A303 Sparkford to Ilchester Dualling Scheme TR010036

8.1 Statement of Common Ground with Environment Agency

STATEMENT OF COMMON GROUND

**PROPOSED DUALLING SCHEME A303 SPARKFORD TO ILCHESTER -
SUBMISSION OF WFD SCREENING AND SCOPING ASSESSMENT
HAWRAT ASSESSMENT AND FLOOD RISK ASSESSMENT (FRA)**

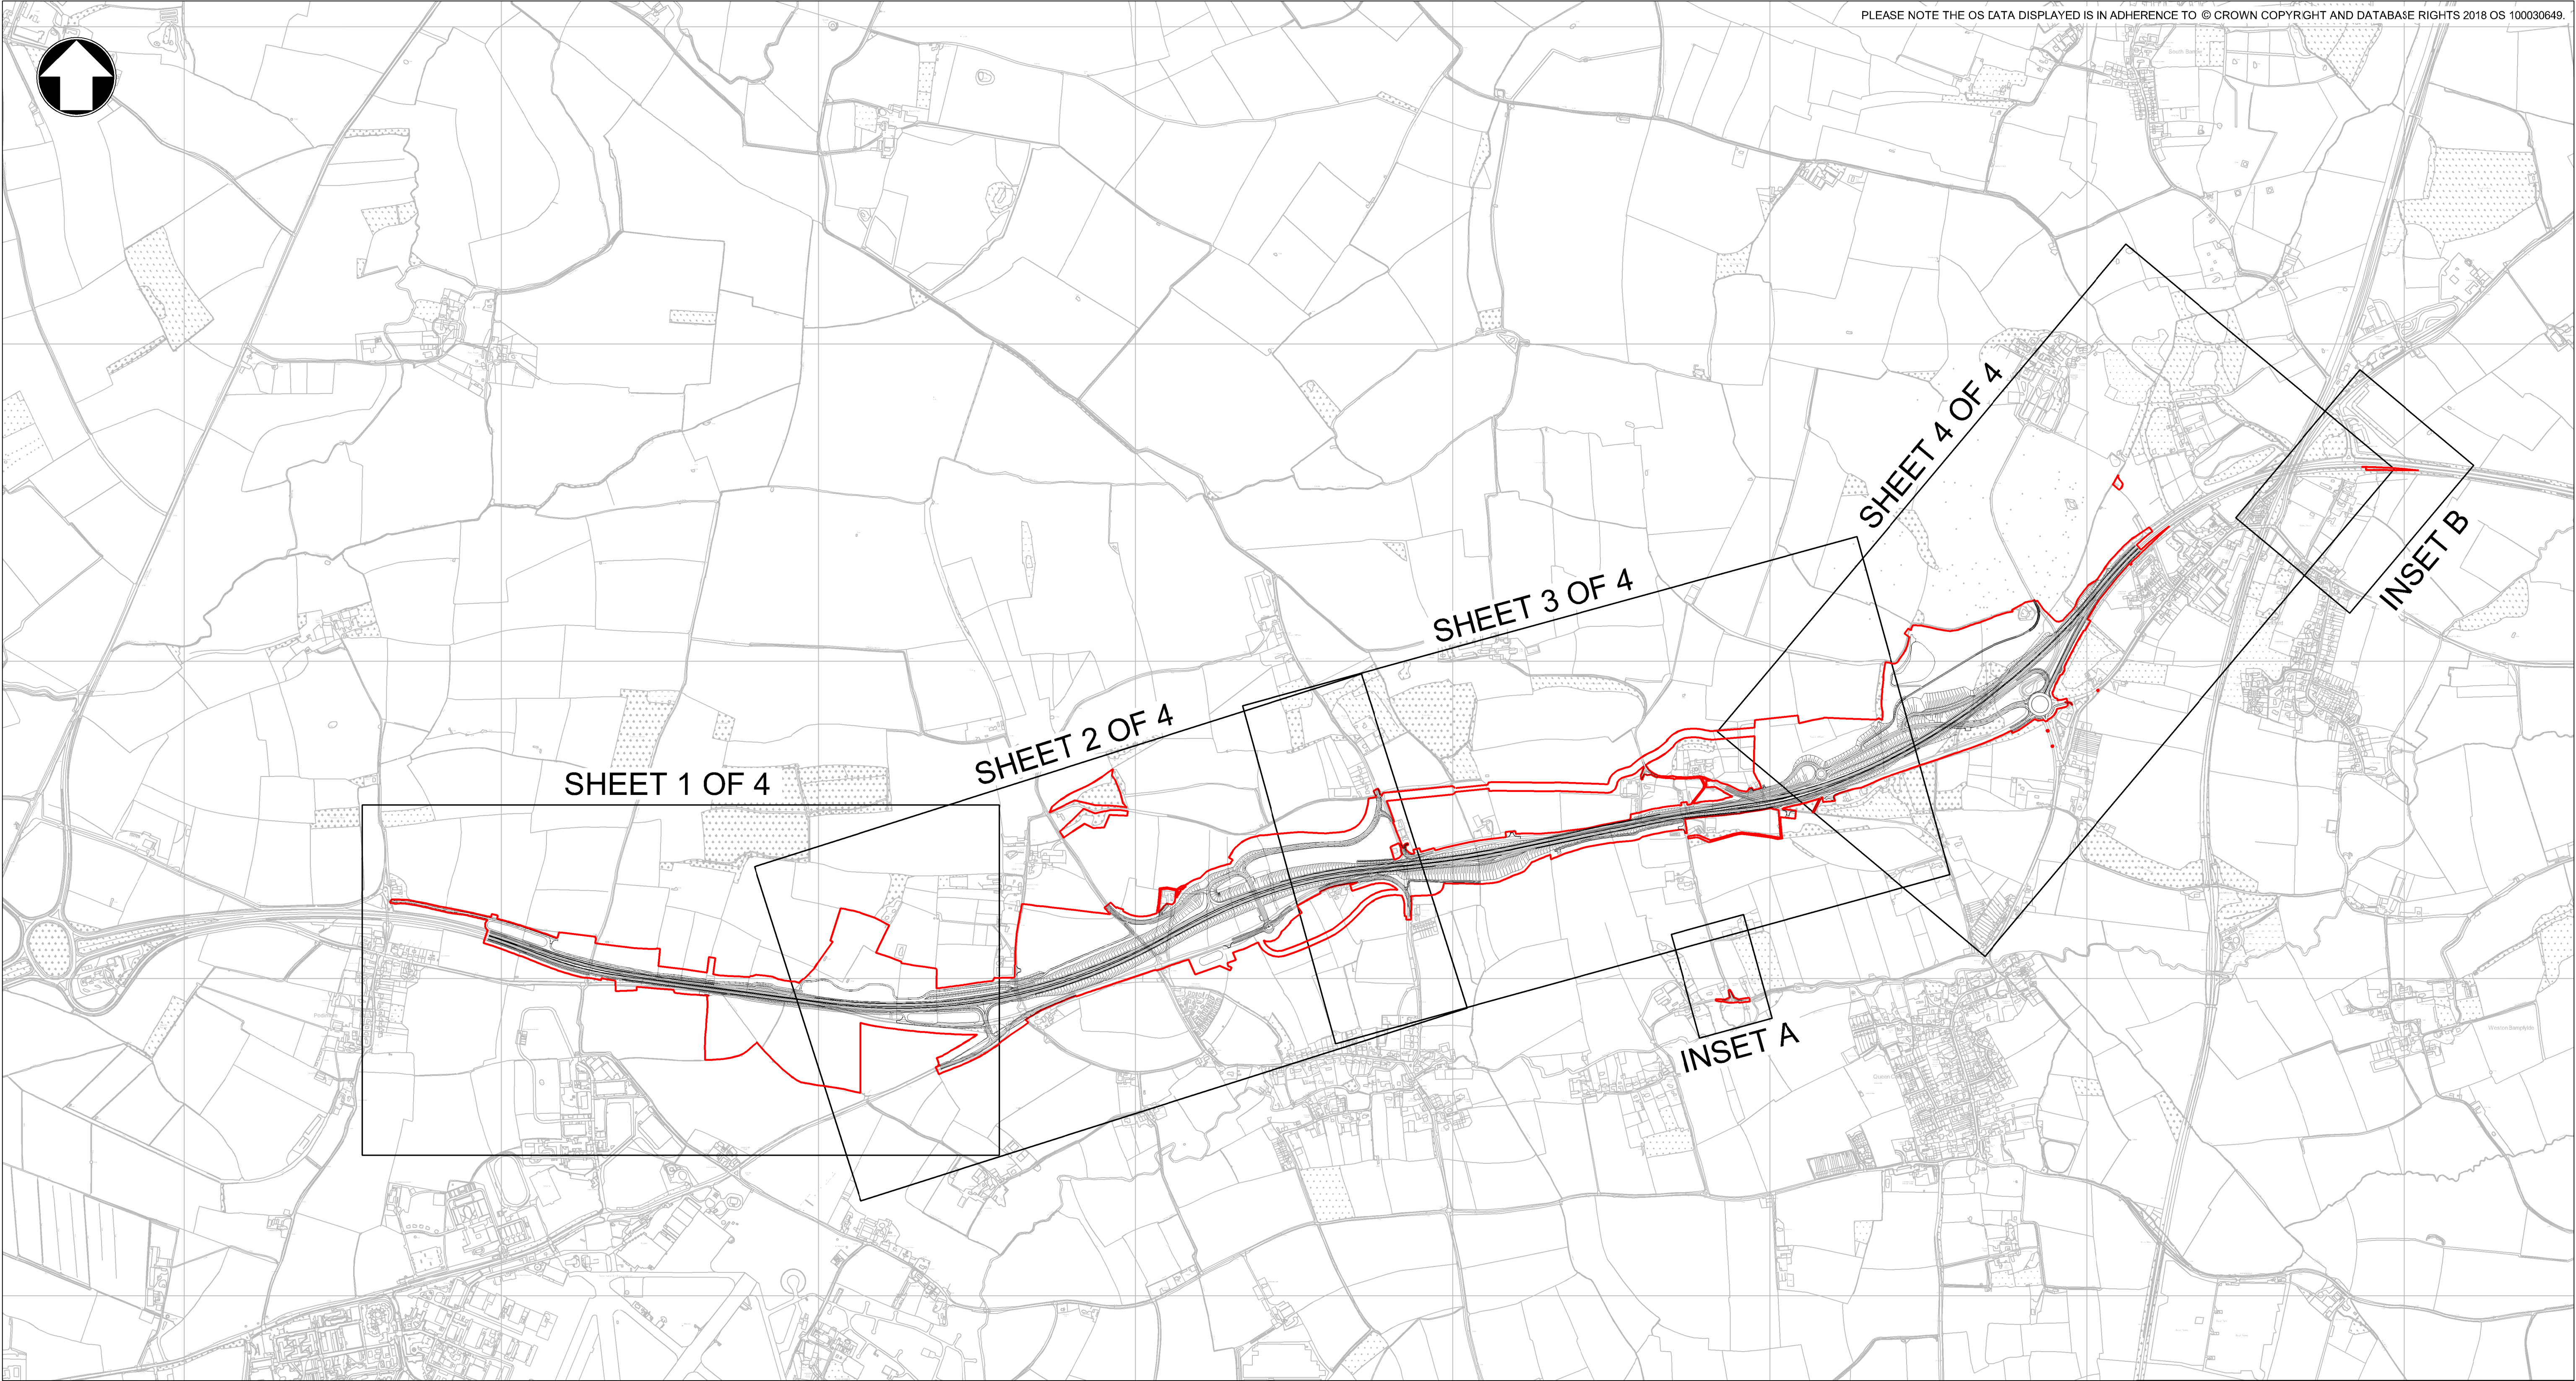
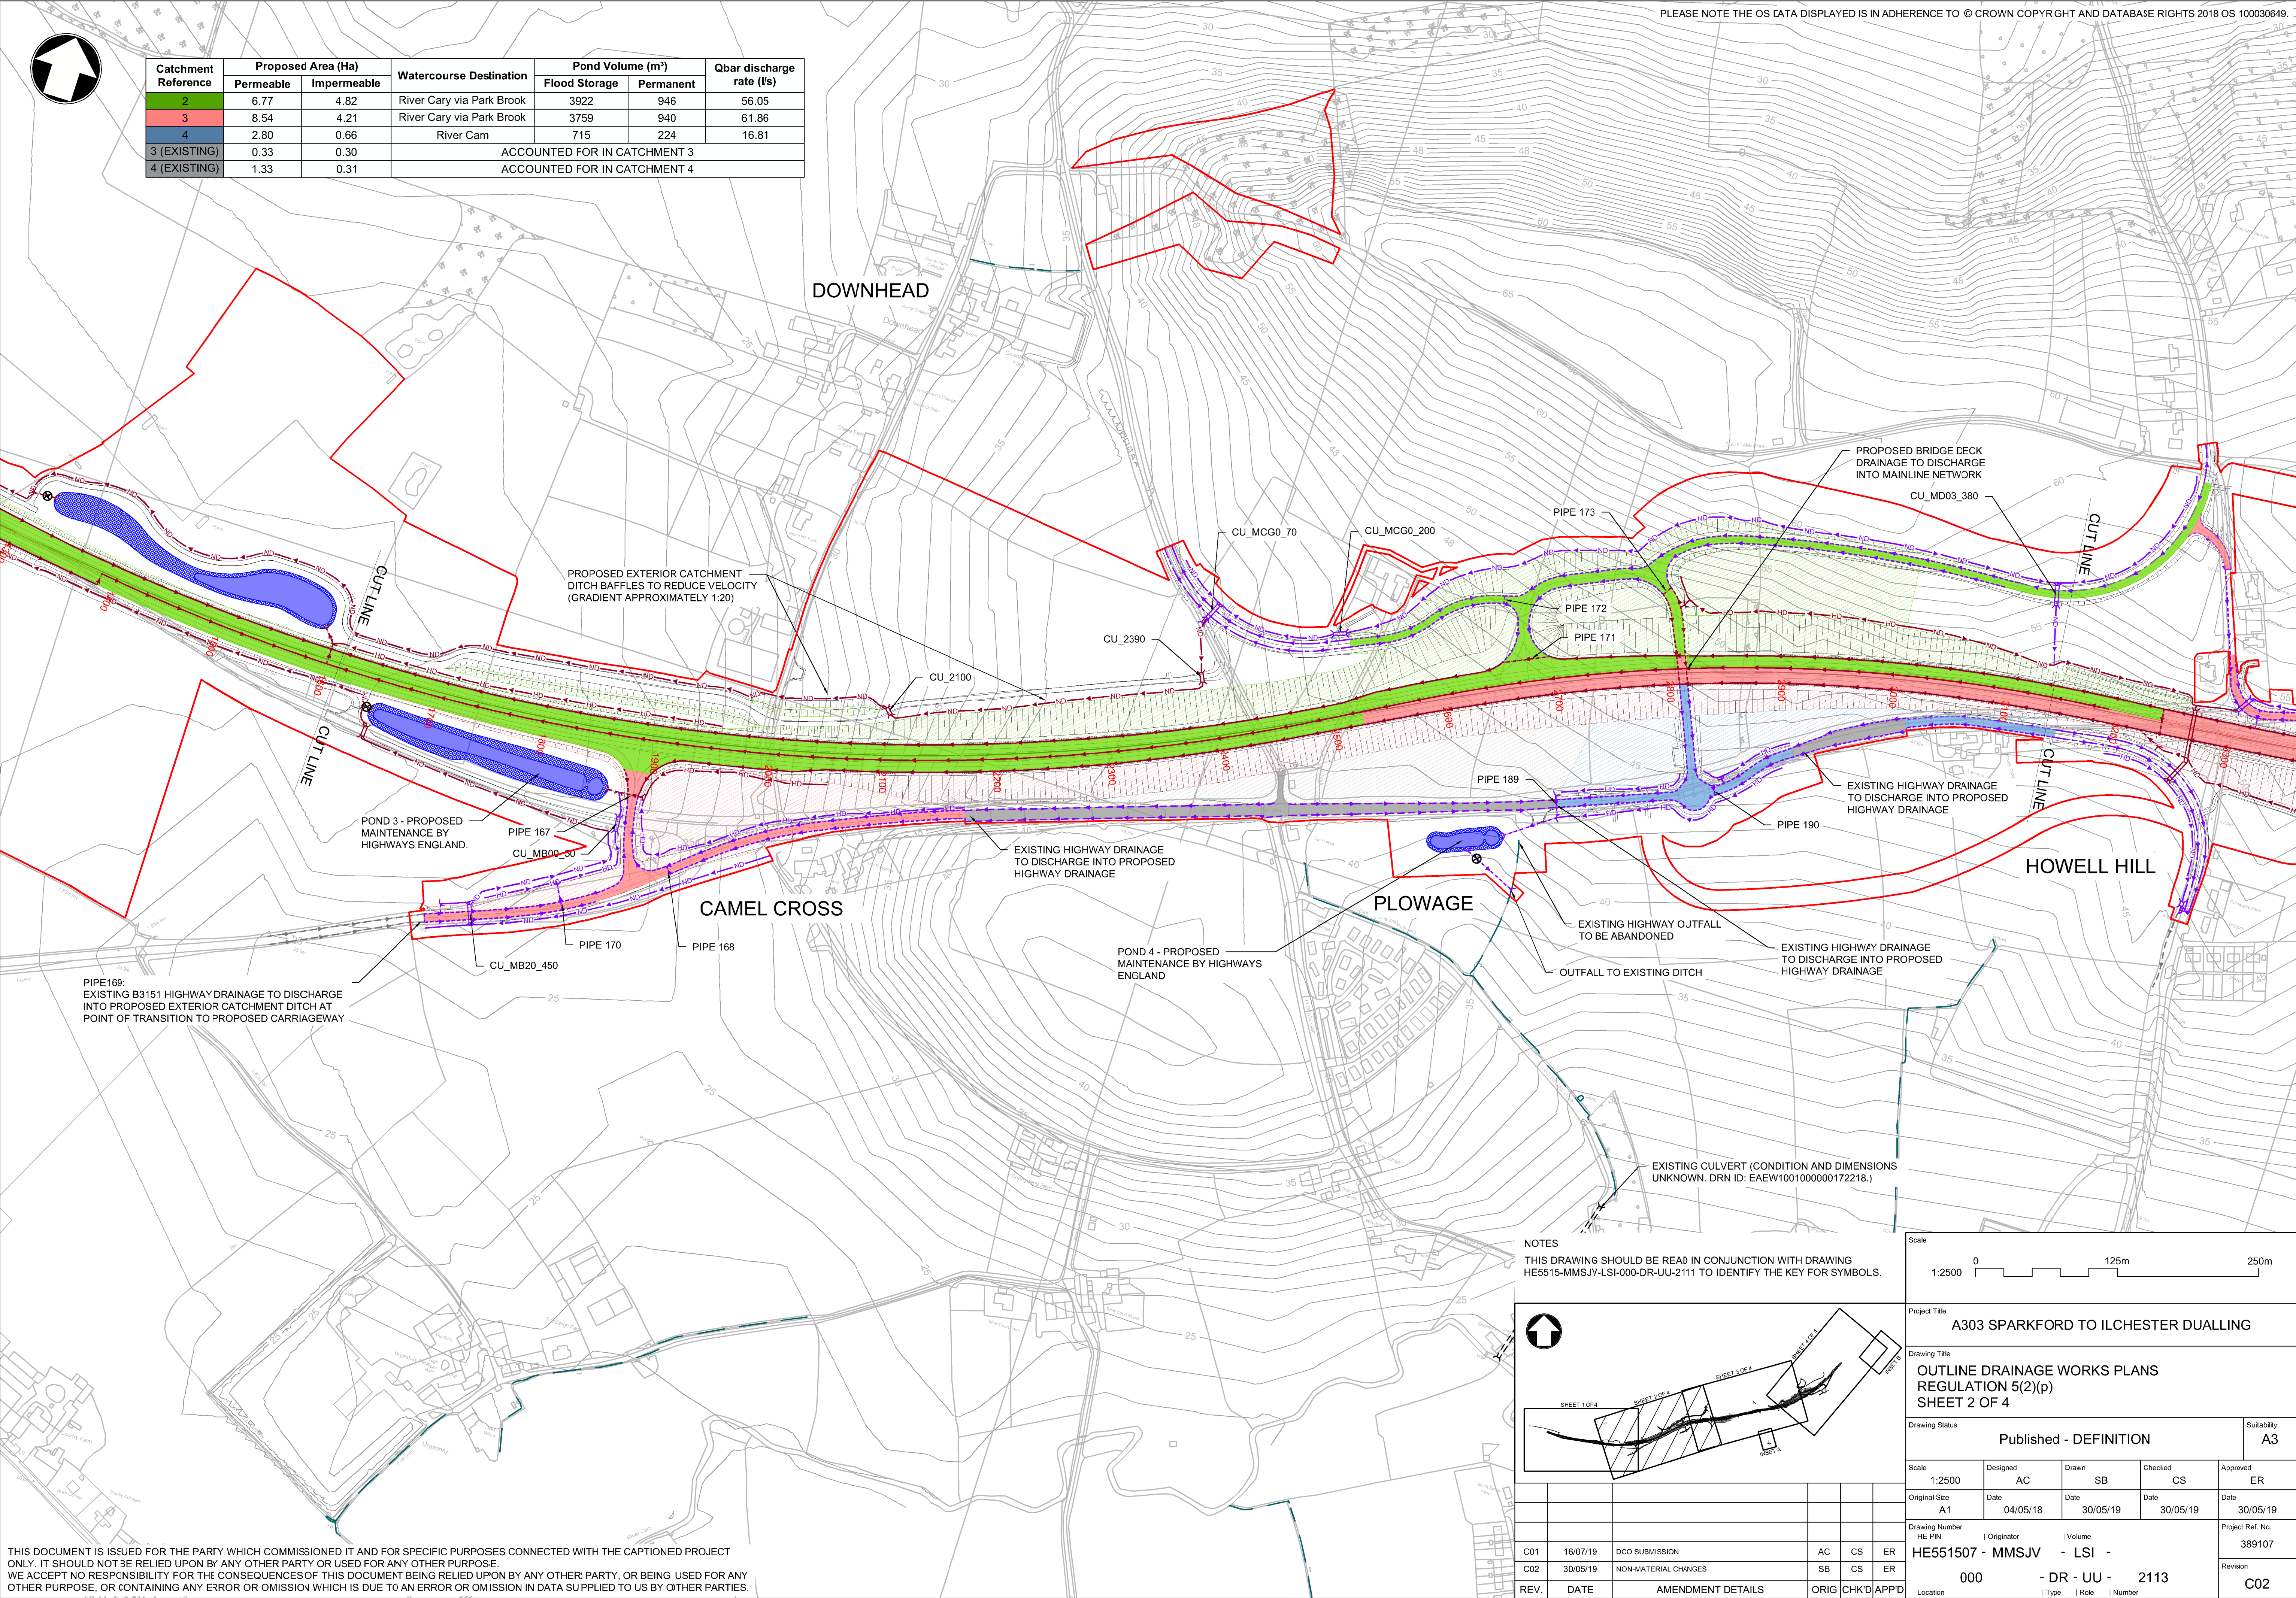
Topic	Sub-section	Environment Agency comment	Highways England response	Status
	Assessment Methodology.		<p>concluded the scheme would have negligible impacts on the water environment (with potential for some benefits / opportunities). Further detailed assessment of the RDWE as part of the Environmental Statement would likely conclude the same negligible effects, and therefore in the interests of proportionate EIA, we believe that the 3 detailed assessments and a supporting RDWE technical appendix which sign posts to these documents is sufficient.</p> <p>It should be noted that potential groundwater effects associated with contaminated land are covered within Chapter 9 Geology and Soils of Volume 6.1 of the ES.</p>	(Appendix A)
Water quantity	Not applicable	<p>It is recommended that the effects of climate change are accounted for in the Flood Risk Assessment (FRA) and drainage strategy. This should include details of surface water attenuation features designed to control runoff to the receiving watercourses.</p>	<p>Accepted.</p> <p>The rainfall intensities used to calculate the design storms include an allowance for the effects of climate change by allowing for the upper bound 40% increase (Flood risk assessments: climate change allowances, Environment Agency).</p> <p>Evidenced in Flood Risk Assessment (Appendix 4.6 of TR010036/APP/6.3) and Drainage Strategy Report (Appendix 4.7 of TR010036/APP/6.3).</p> <p>Attenuation feature discharge rates and volumes shown in Outline Drainage Works Plans (TR010036/APP/2.11).</p>	AGREED (Appendix A)

Topic	Sub-section	Environment Agency comment	Highways England response	Status
		Confirmation is sought that the proposed design will control the overall volume, as well as the overall rate of runoff with sufficient attenuation provided.	Attenuation has been provided, with discharge limited to 1% annual exceedance probability (1 in 100-year event) plus 40% to account for the effects of climate change (Flood risk assessments: climate change allowances, Environment Agency), to no greater than the undeveloped rate of runoff, determined by the calculation of the mean annual peak rate of runoff for a greenfield site (Qbar). Preliminary design discharge rates and volumes shown in Outline Drainage Works Plans (document reference TR010036/APP/2.11).	AGREED (Appendix A)
		With reference to flood risk management issues, the documentation does not include the Agency's confirmation that the proposed route is located outside designated flood zones 2 and 3 and is therefore not liable to any significant main river fluvial or tidal risks. The highlighted risks are from surface water and or IDB/ordinary watercourses.	The Flood Risk Assessment considers all sources of flood risk, including but not limited to the fluvial and tidal flood zones, ordinary watercourse and surface water runoff. Evidenced in Flood Risk Assessment (Appendix 4.6 of TR010036/APP/6.3).
